Arun District Council
Arun Civic Centre
Maltravers Road
Littlehampton
West Sussex BN17 5LF
Planning General Enquiries
Tel: (01903) 737756 Fax: (01903) 730442
Dx: 57406 Littlehampton
Minicom: 01903 732765
e-mail: planning@arun.gov.uk
website: www.arun.gov.uk/planning

Our Ref: BN/69/16/PL
Your Ref:

Development 5 no. dwellings comprising 2 no. 4- bed houses, 2 no. 3- bed houses and 1 no. 3- bed bungalow, with access and ancillary works
Location Land East of Toll Cottage Lake Lane Barnham

PLOT 3
FIRST FLOOR

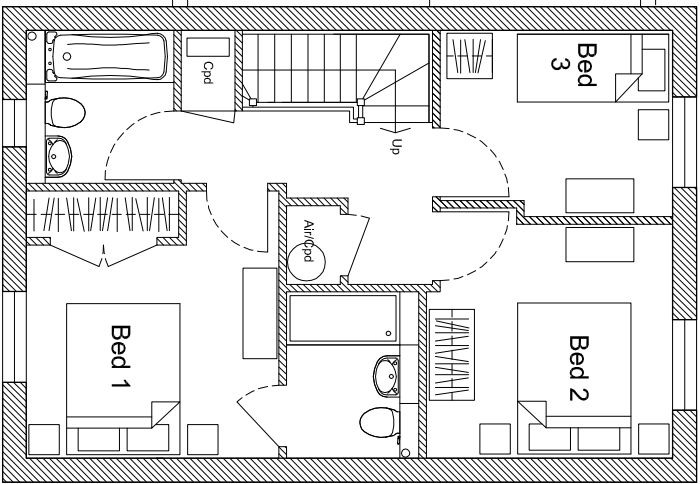
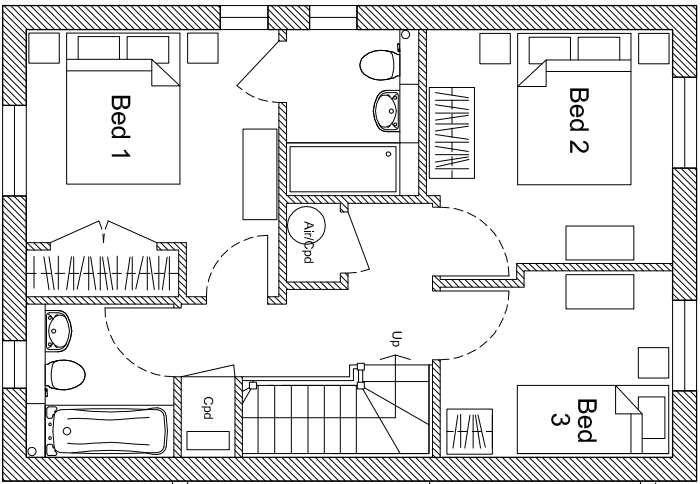
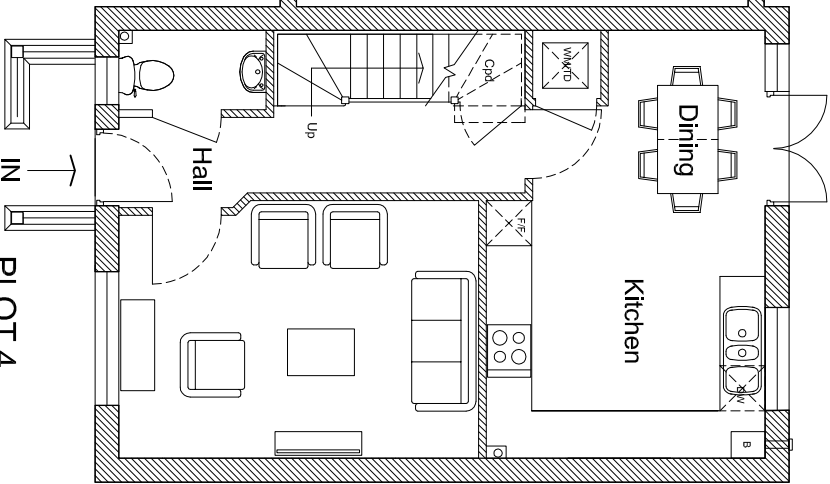
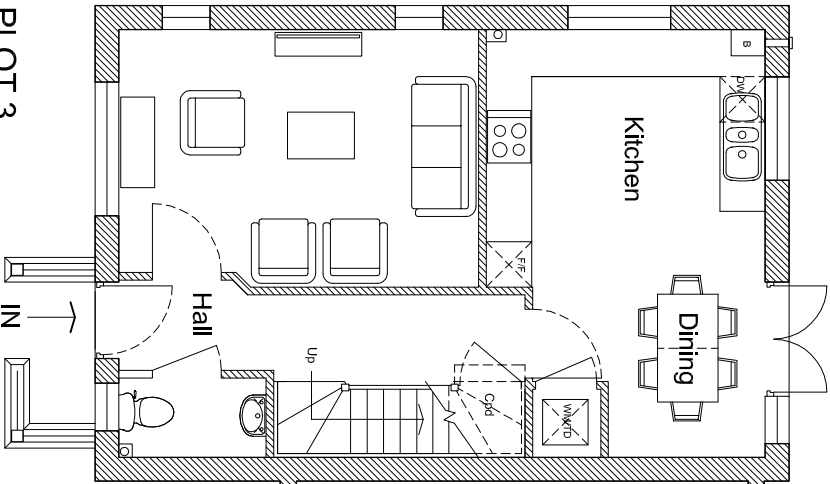
The size of the window is inconsistent between the first floor plan and west elevation of plot 3
